**New High School in Bungendore (SSD-14394209)
Request for additional information**

The proposal was presented to the State Design Review Panel (SDRP) on 8 December 2021 (third review). You are requested to address the matters raised in the SDRP advice sheet dated 22 December 2021 (attached). Please include the response to these matters as part of the Submissions Report.

PROJECT: BUNGENDORE HIGH SCHOOL
RE: State Design Review Panel – 08.12.21 (third review)

12 Revised Covered Walkway Strategy

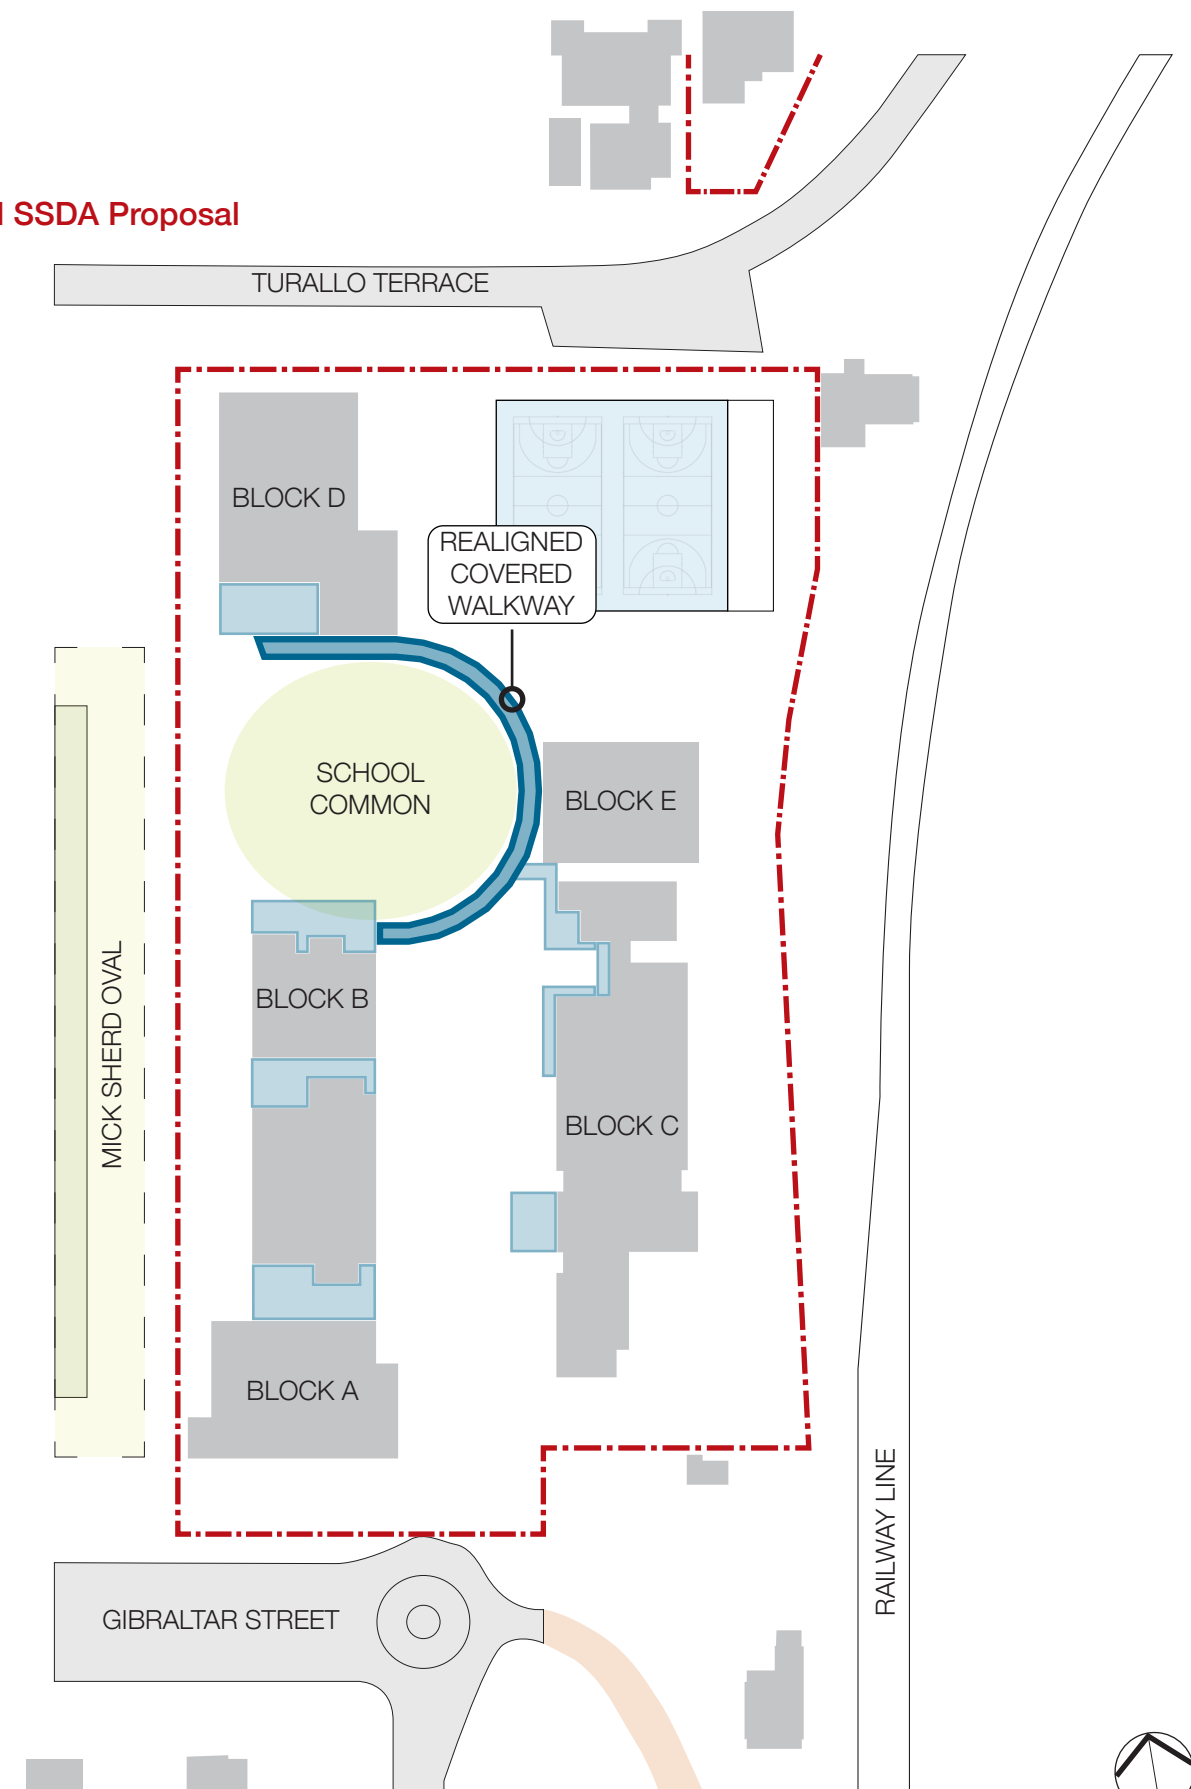
11. The covered walkway between the canteen and the science building truncates usable open space. Relocate the covered walkway to the perimeter of the circular oval to further define this space which acts as the open space heart of the campus.

13 Fencing Strategy

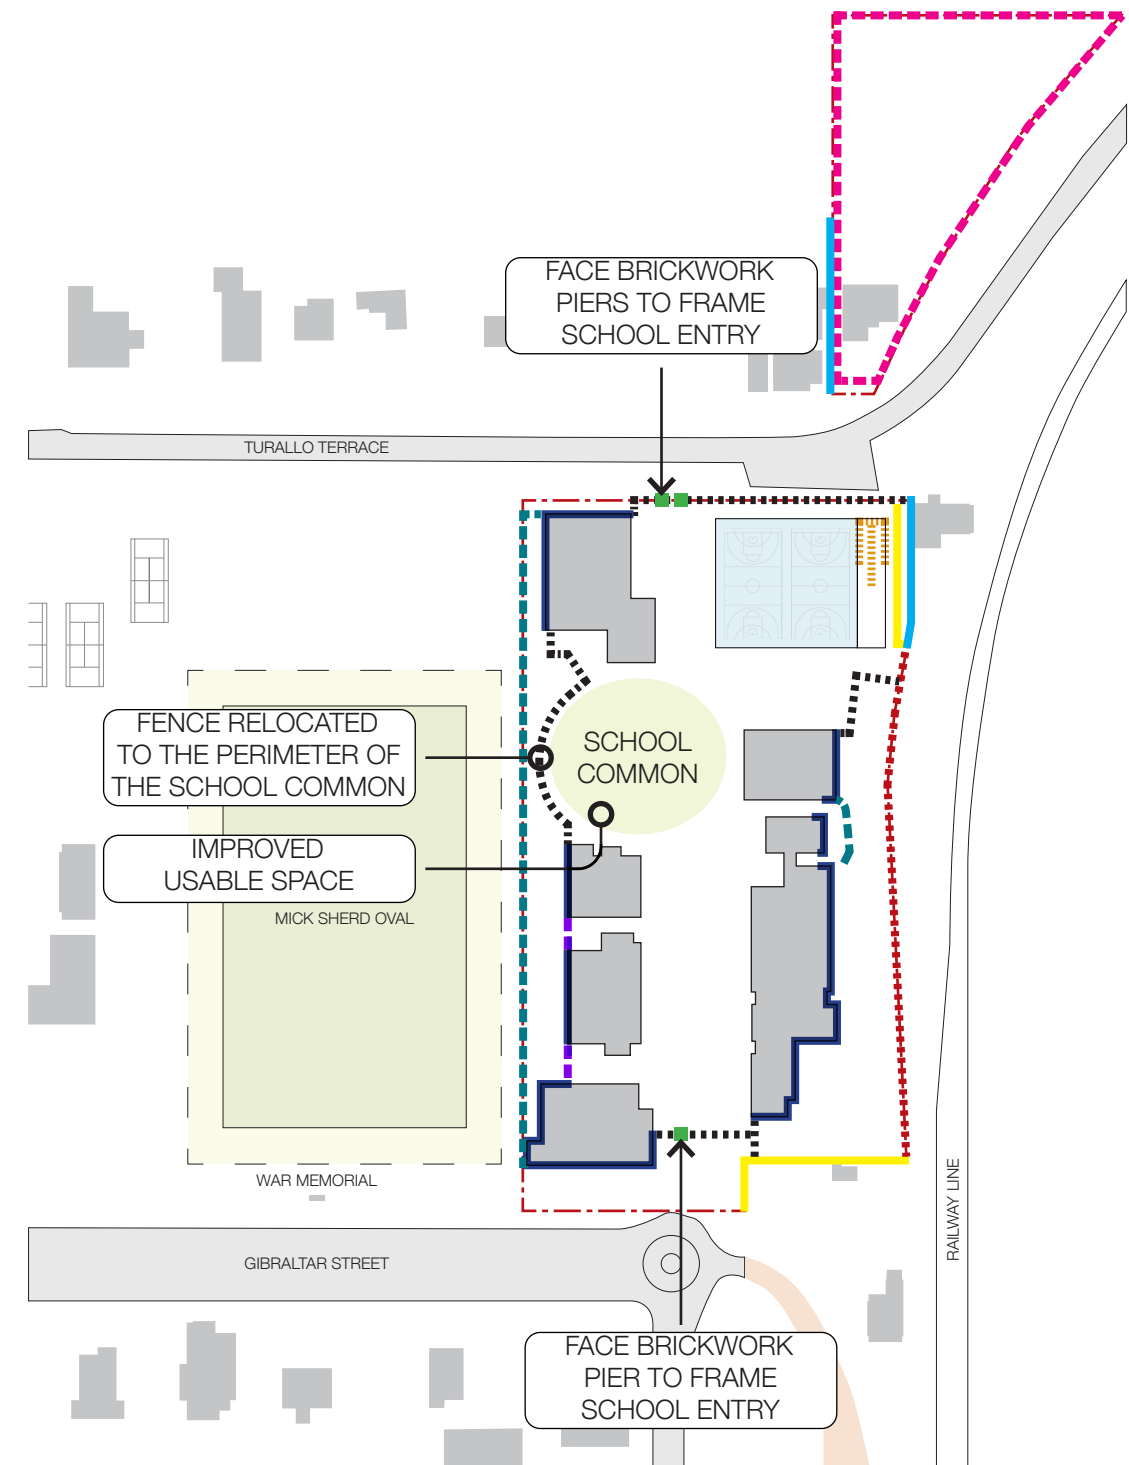
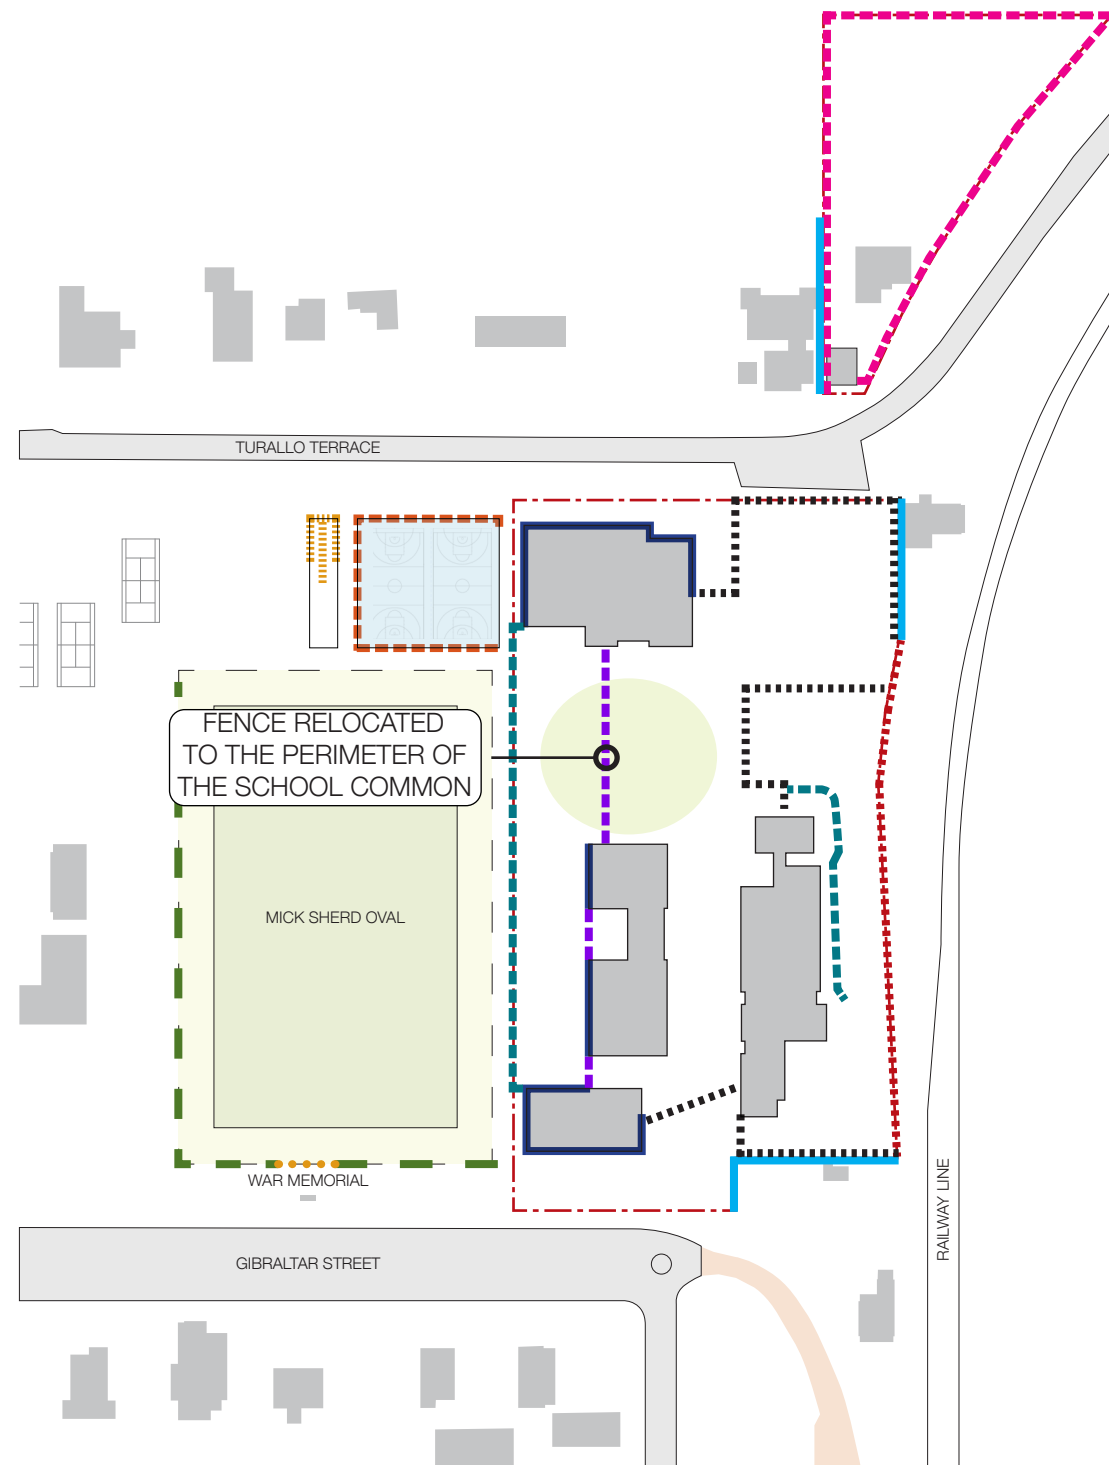
10. Revise the fencing strategy. The current proposal is unacceptable as is not in keeping with the character of the town and a school within a rural setting. The fencing strategy impacts on the useability of open space within the campus and truncates the open space unnecessarily. Provide

updated details on the fencing strategy including clear articulation of what needs to be secured whilst considering place and context.

1 GIBRALTAR STREET

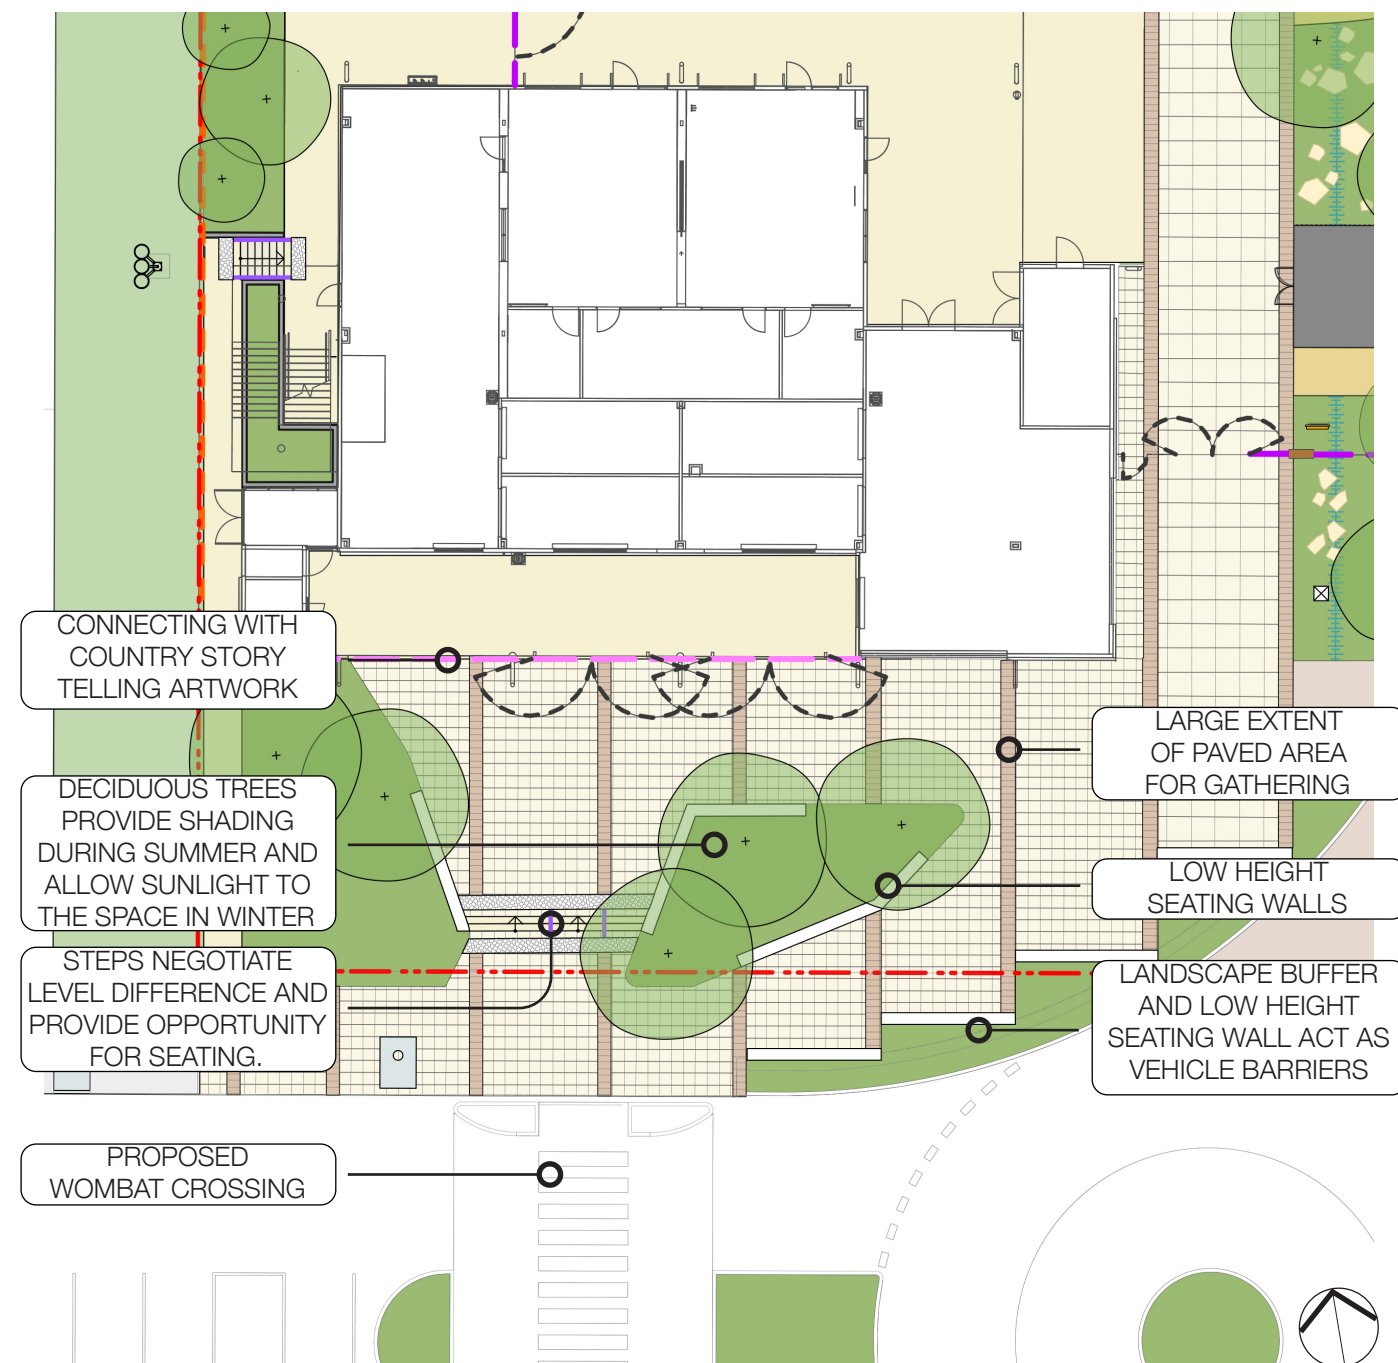
12. Further development of the edge conditions to the campus is required. Provide details through 3D sketches, sections and elevations on the landscape design, perimeter seating for the sport fields, entry/waiting areas, and student experience of the campus.

17. Provide further detail on the entry experience for visitors and users of the campus.

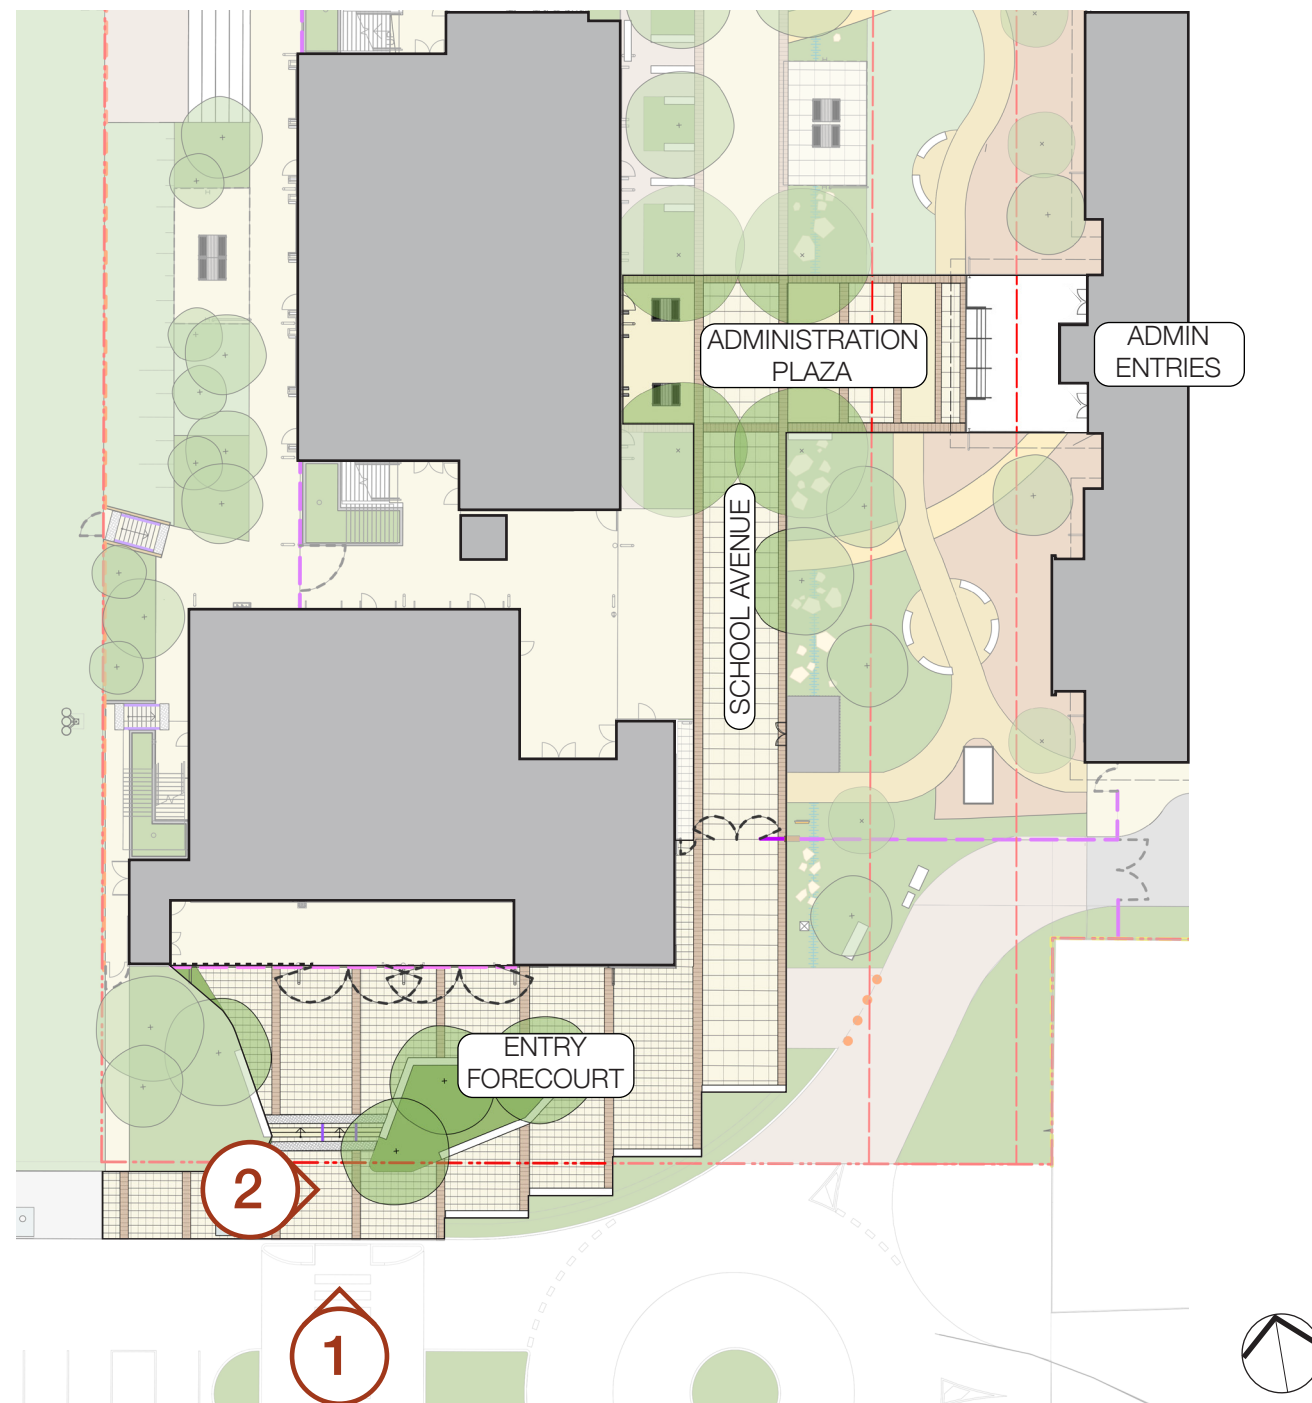
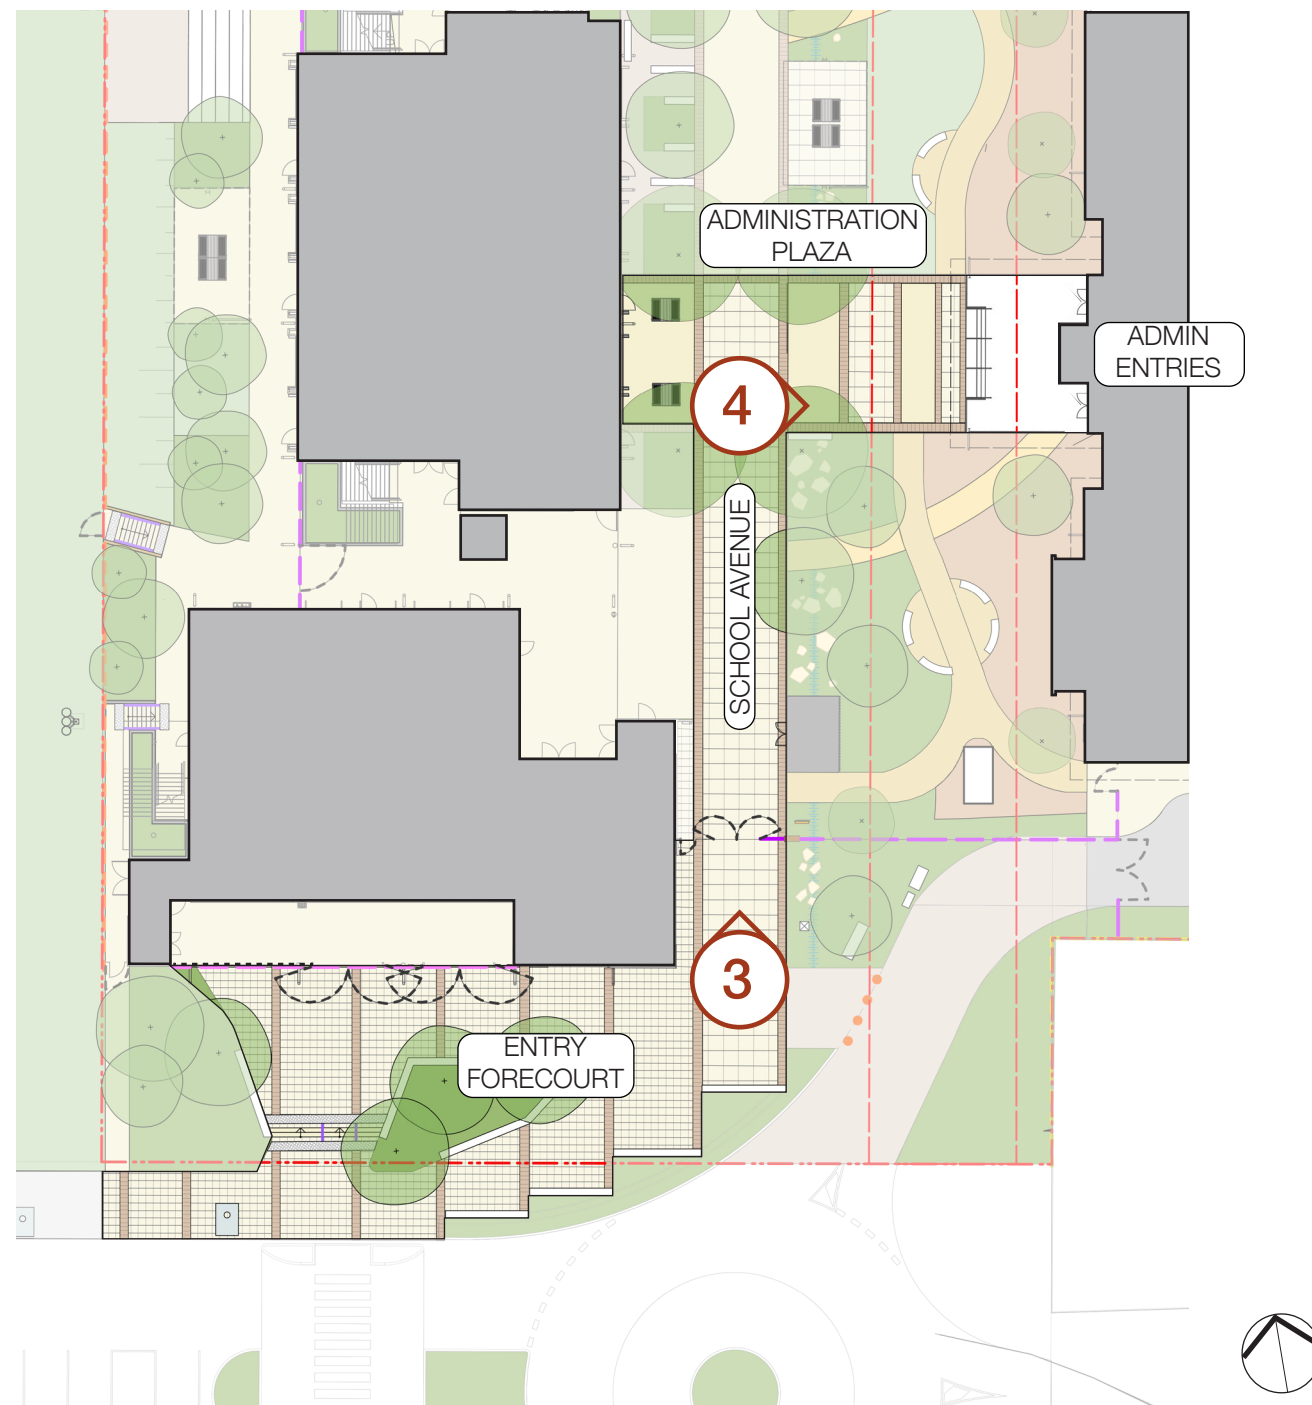
16. Maximise the sites permeable surfaces including carparks, entry forecourts and the Majara Street axis.
17. Provide further detail on the entry experience for visitors and users of the site.
